6 March 2020

**Port Kembla Gas Terminal — Modification 1  
Response to request for additional information**

The table below provides responses to the requests for additional information from the Department of Planning, Industry and Environment; Environment Protection Authority (DOC20/115960-2), and the Department of Primary Industries — Fisheries (C20/99 and C19/696).

Figure 3-1: Fatality Risk Contours – Base Case

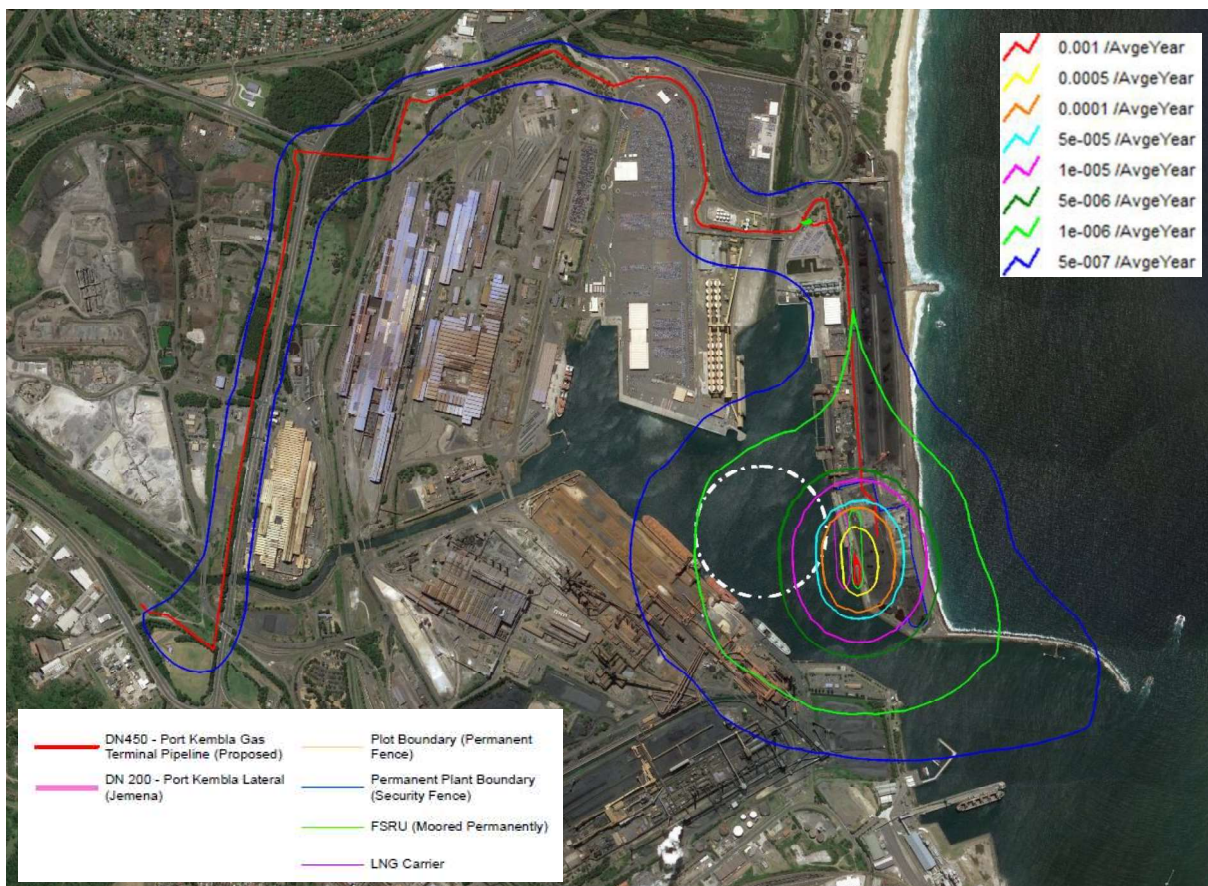
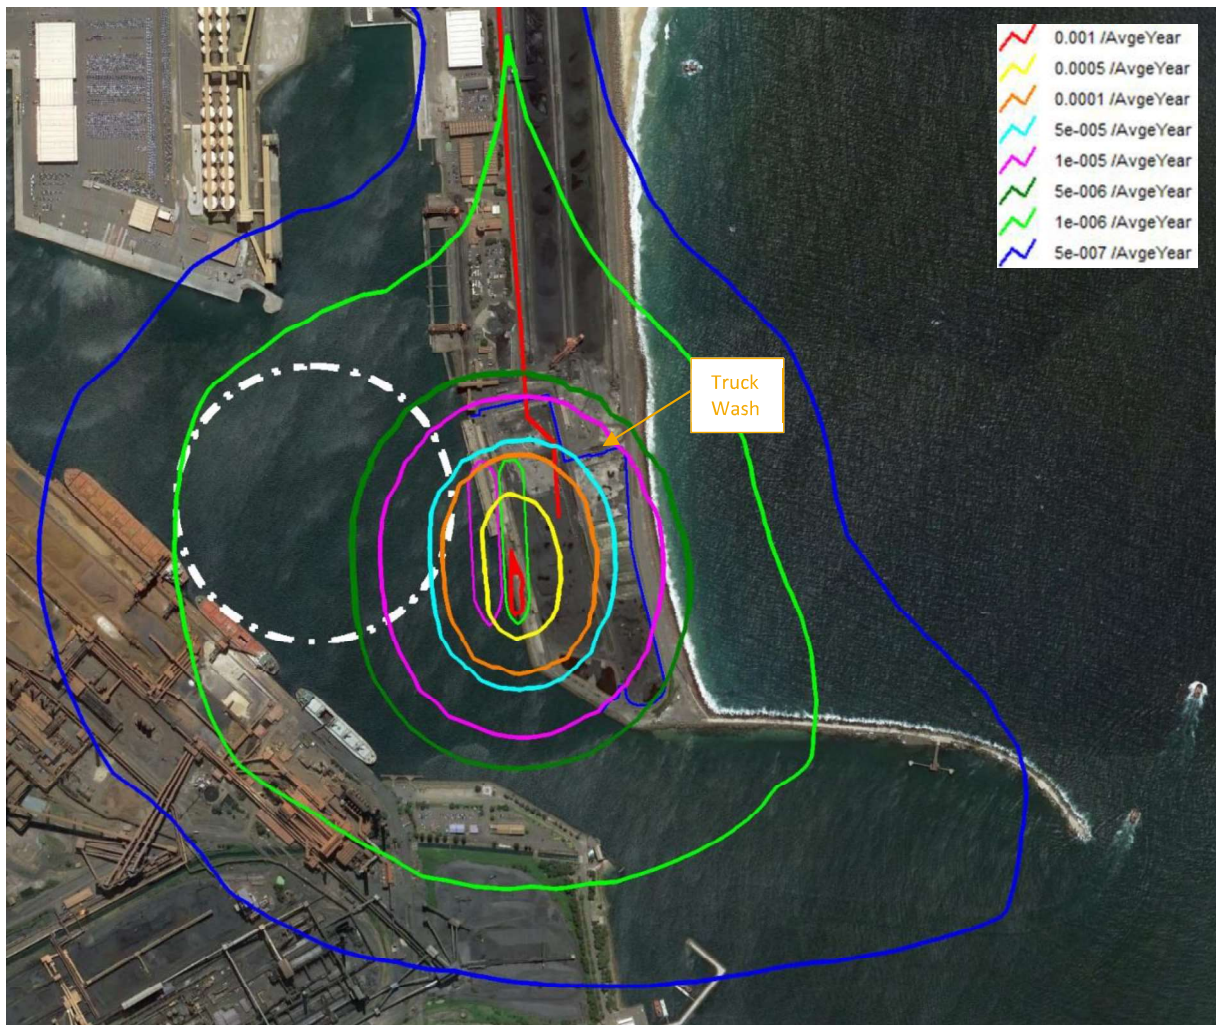
Issue	Response																														
<p><u>Base case risk contours</u></p> <p>The submission makes reference to the preliminary hazard analysis of the proposed modification.</p> <p>It states that the risk contours in the preliminary hazard analysis of the proposed modification are smaller than the risk contours in the environmental impact statement.</p> <p>It requests clarification on the assumptions for each modelled scenario and a comparison of the risk contours in the proposed modification and the environmental impact statement.</p>	<p>The assumptions for each modelled scenario in the preliminary hazard analysis of the proposed modification are summarised below. It should be noted that the preliminary hazard analysis of the proposed modification also includes a refined location of the regasification unit within the FSRU based on refined design information placing it about 37 metres from the front of the vessel, compared to 46 metres from the front of the vessel in the EIS.</p>

Issue	Response
	<p>The risk contours for the EIS base case and modification base case are shown for comparison in Figure 1 and Figure 2. As shown, there is some increase in the outer risk contours to the west and the south-east from the EIS base case to the modification base case, which is attributable to the increase in assumed shipments per year from 26 per year in the EIS base case to 52 per year in the modification base case. The inner risk contours have not materially changed in extent but have moved slightly to the south as a result of the refined location of the regasification unit in the preliminary hazard analysis of the proposed modification discussed above. Further, risk contours for the low season (Figure 3) were considerably reduced compared to the modification base case while risk contours for high season sensitivity analysis (see Figure 5) were similar to the modification base case.</p> <p>As discussed in the proposed modification hazard and risk assessment, the proposed modification would not introduce additional hazardous inventories or scenarios. Consistent with the findings of the EIS, the assessment found criteria for sensitive areas, residential areas and commercial development would be met in all cases, as would the criteria for injury and propagation. Limited risks to open space and industrial areas have been identified which, consistent with the risks identified in the EIS, would include a section of Seawall Road and the small offsite area west of the truck washing facility associated with the coal terminal adjacent to Berth 101.</p>
